Our Reference: SYD17/01416/03  
Department Ref: SSD 8800

**PARRAMATTA LEAGUES CLUB HOTEL (SSD 8800)  
1 EELS PLACE, PARRAMATTA**

Roads and Maritime has reviewed the submitted application and provides the following advisory comments to the Department for consideration:

DRAWING TITLE
SWEEP PATH ANALYSIS DIAGRAM - SRV

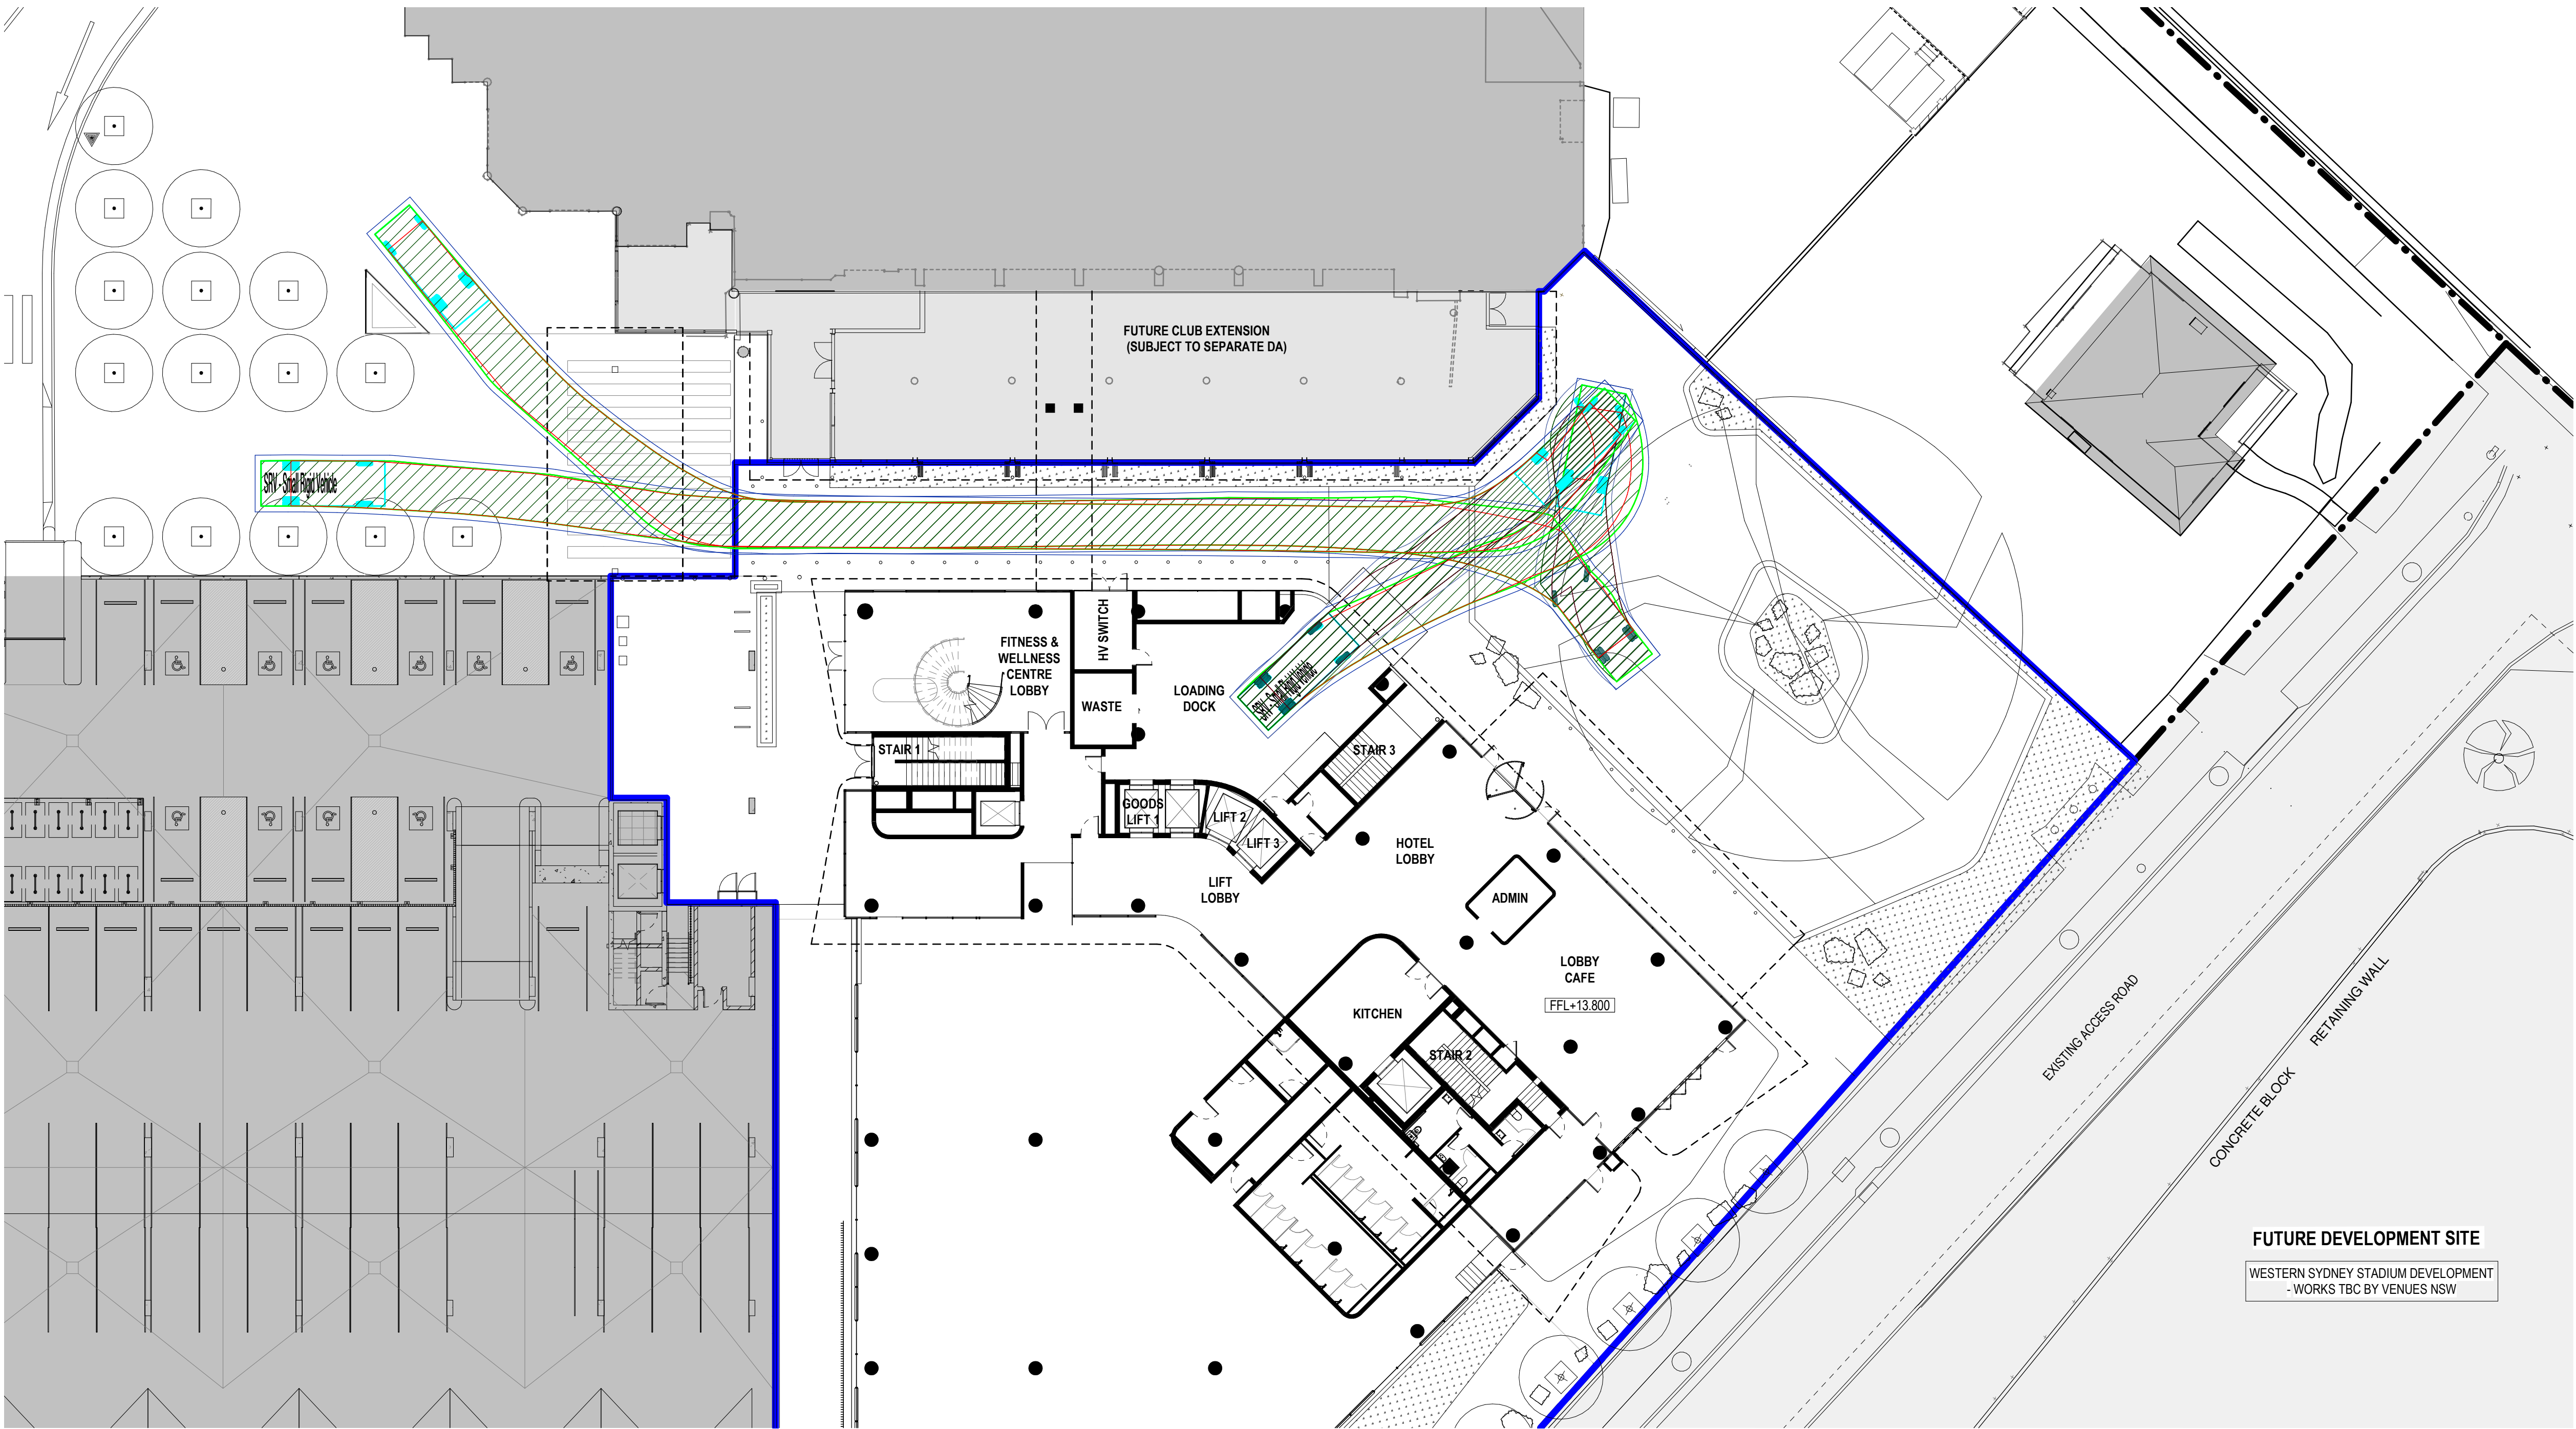
3. Minimal information has been provided as to the mitigation measures that are to be implemented by the site along the new access point and hotel courtyard/delivery dock.

It seems that services vehicles will need to perform multiple forward and backwards manoeuvres, in a highly pedestrianised area. Roads and Maritime recommends that all vehicles in a highly pedestrianised area should be separated and be designed to enter and exit in a forward direction. Before, during and after events at Western Sydney Stadium the hotel will be restricted and will be required to develop a Plan of Management.

DRAWING TITLE
SWEEP PATH ANALYSIS DIAGRAM - MRV

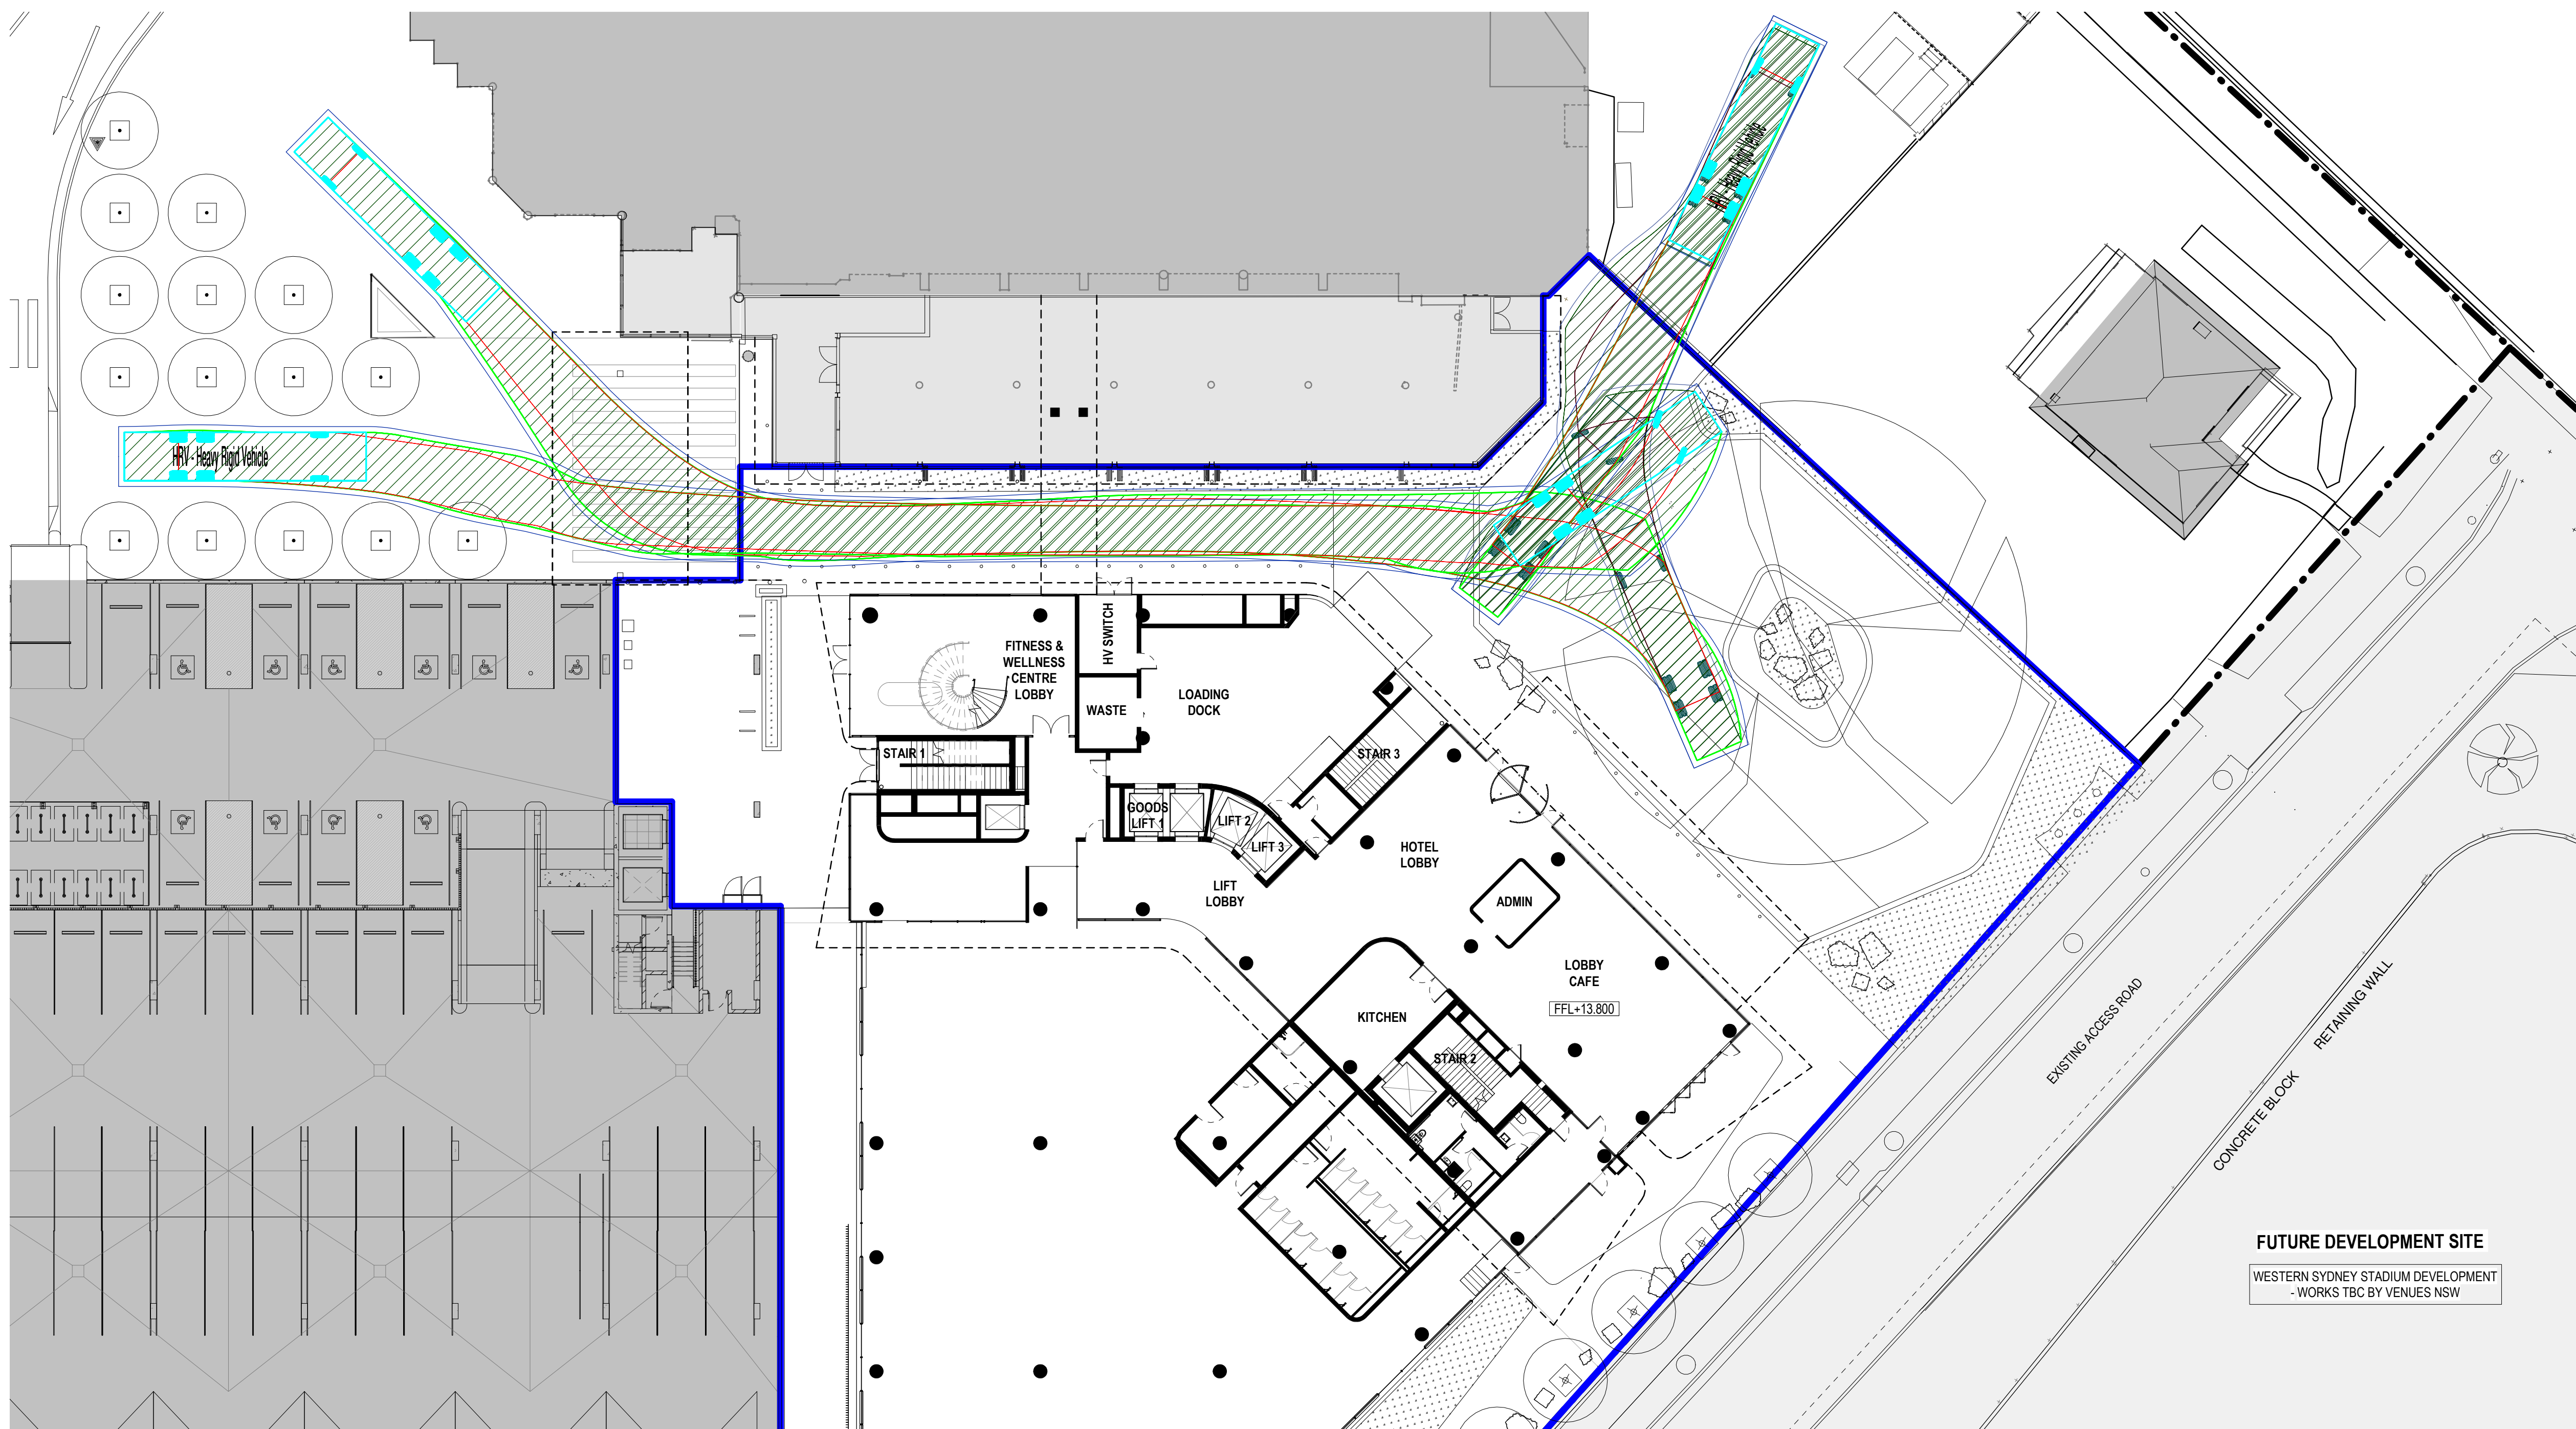
2. After reviewing the swept paths, Roads and Maritime notes that the largest vehicle 12.5m currently straddles the kerb and cannot have simultaneous entry/exit at the new access point. Roads and Maritime advises that a revised swept path analysis should be performed with a standard 14.5m vehicle (coach) indicating no straddling of the kerb and allows for simultaneous entry/exit movements.

Unless this can be performed satisfactorily, the proposed new access point cannot be supported on safety and efficiency grounds.
